Subject: LU/248/19/DOC - Land at Toddington Farm, north and west of 1-3 Toddington Lane, Wick, BN17 7PP

In relation to the above application to discharge of condition 10, Randall and Chisnall Construction Ltd.'s Construction, Environment and Management Plan, dated May 2019 has now been reviewed. It is assumed that an amended version of this report will be supplied when the missing information is determined (Key Dates, drain locations, service locations, H&S consultant etc.) however in the meantime, Environmental Health is not able to recommend discharge of this condition, based on the following:

Construction Management Plan Layout

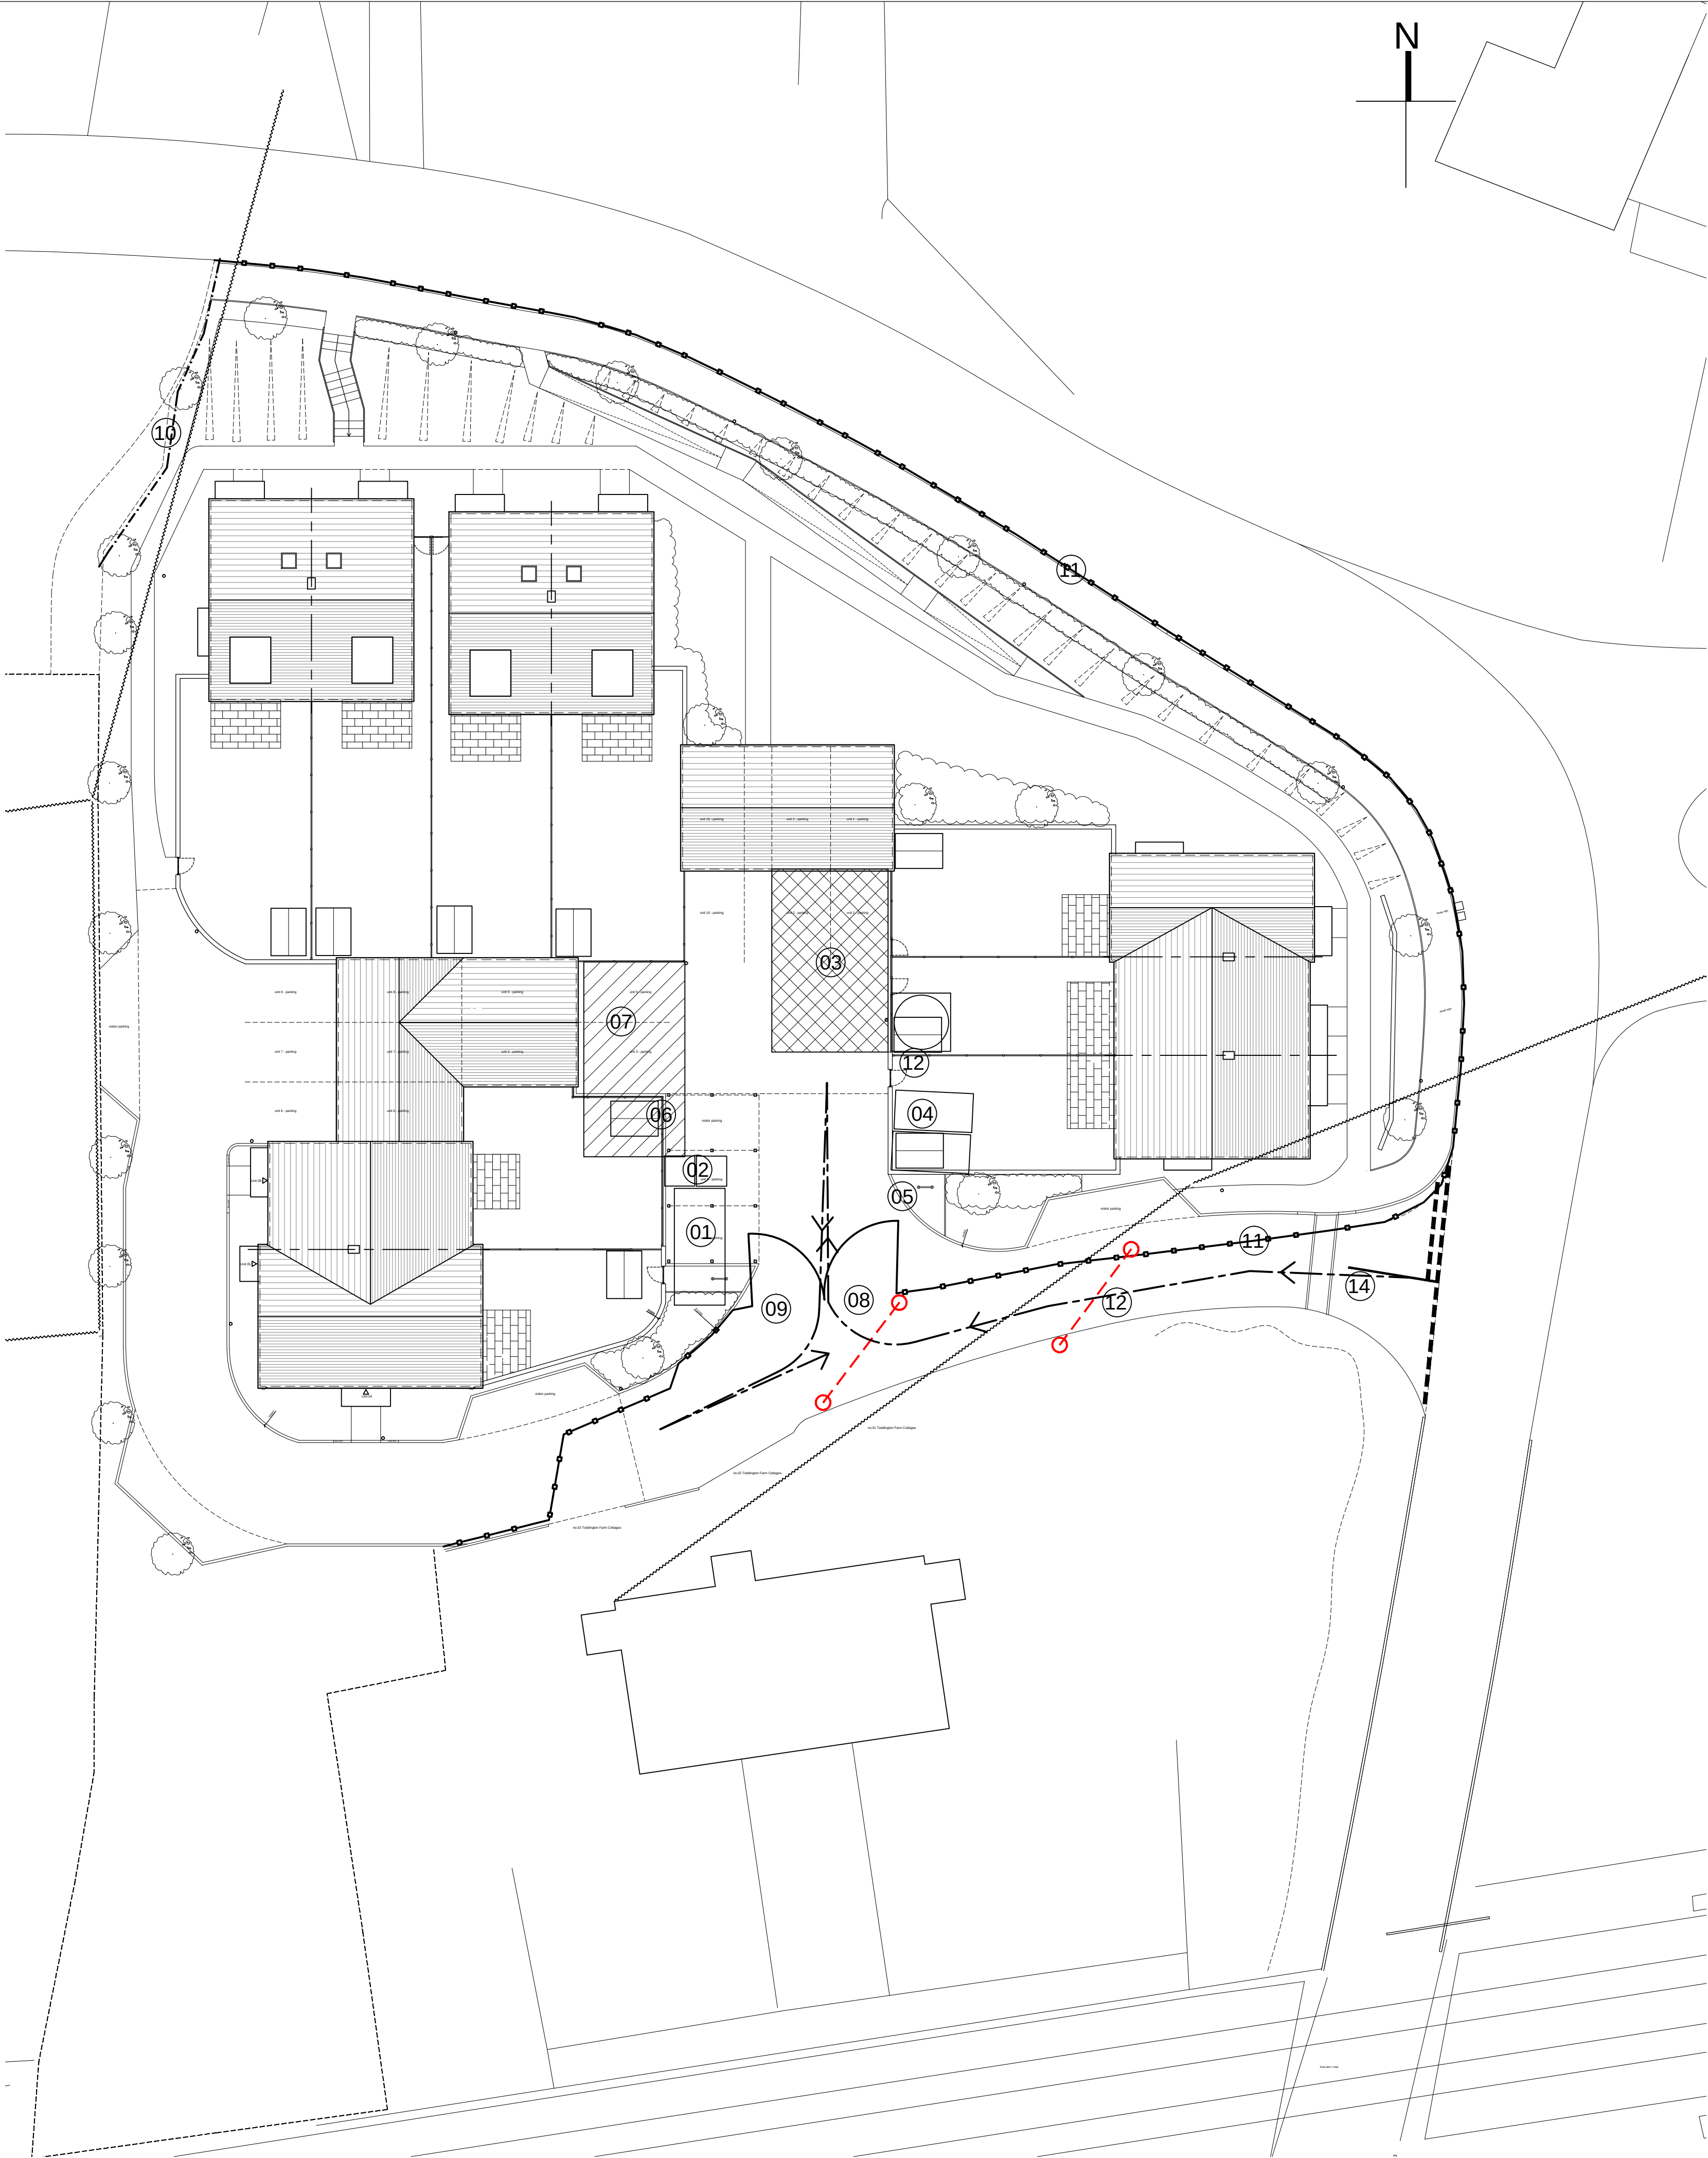
- 2.4 Wheel Washing – what provisions will be made for the disposal of wheel wash water?
- 3.2 Health and Safety Goals – the Health and Safety (DSE) Regulations were amended in 2002, the Environmental Protection Act was published in 1990.
